Application No: FG/67/22/HH
Site Address: 19 Singleton Crescent Ferring BN12 5DE
Description of works: Conversion of roofspace to habitable use and addition of dormers.

Thank you for your internet representation made on 23rd May 2022 which has been recorded as an objection with the comments as follows:

Plans & Elevations As Proposed

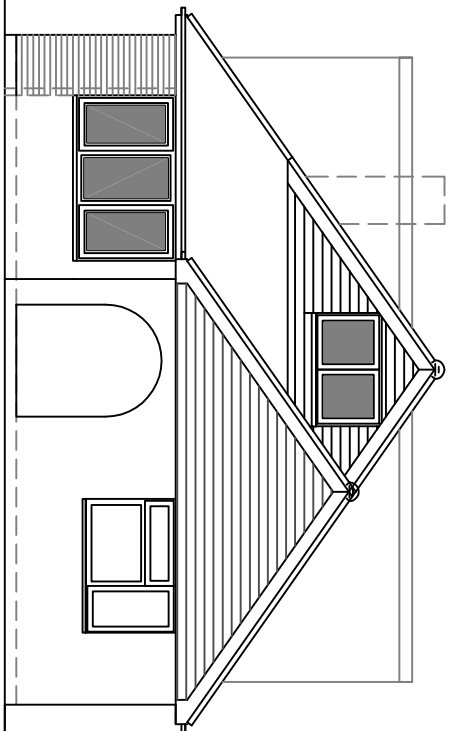
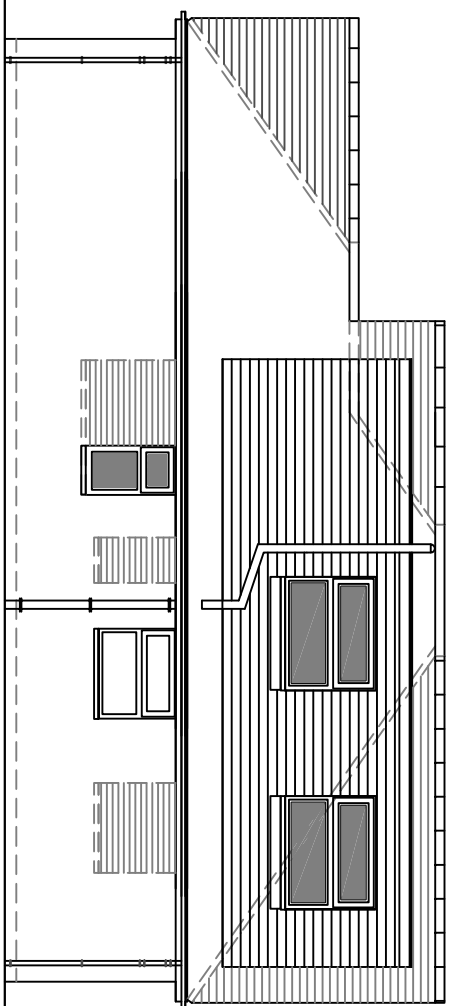
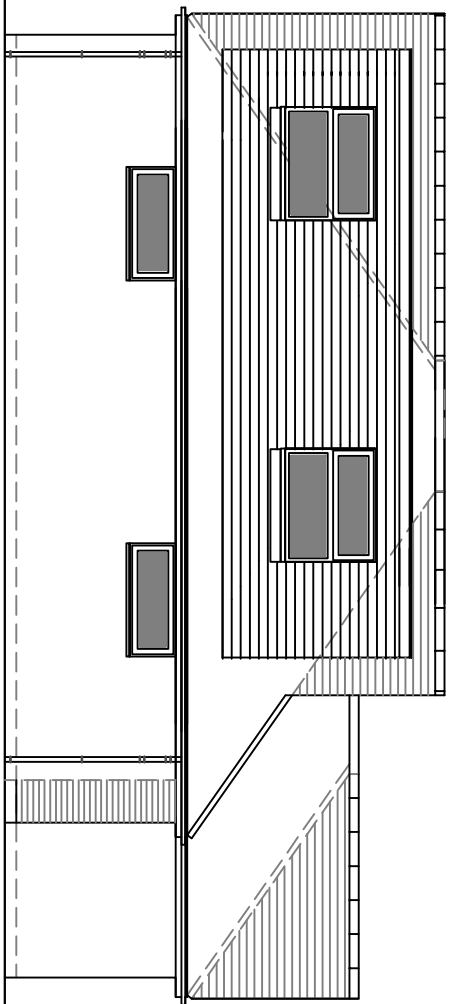
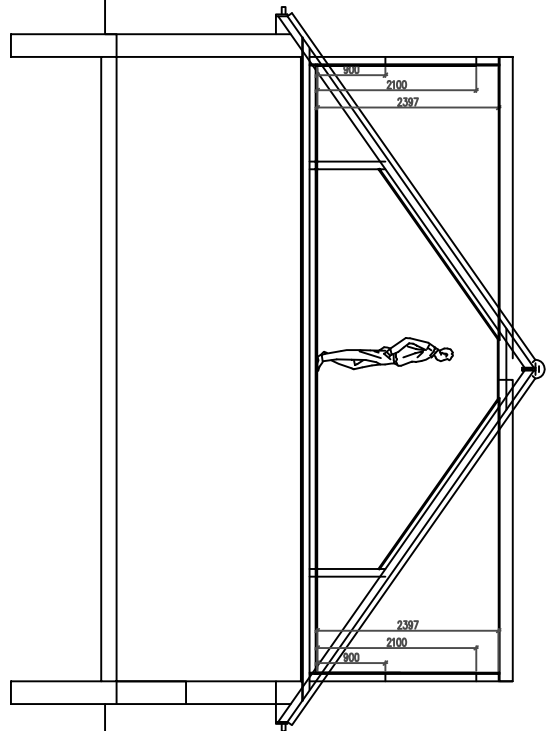
Ferring Parish Council object to the proposed conversion which, by reason of its scale and mass, will be disproportionate to the host building and overly dominant, both for neighbours and from the street scene. This is particularly accentuated on the eastern elevation due to its close proximity to the boundary and overshadowing of the neighbouring property.
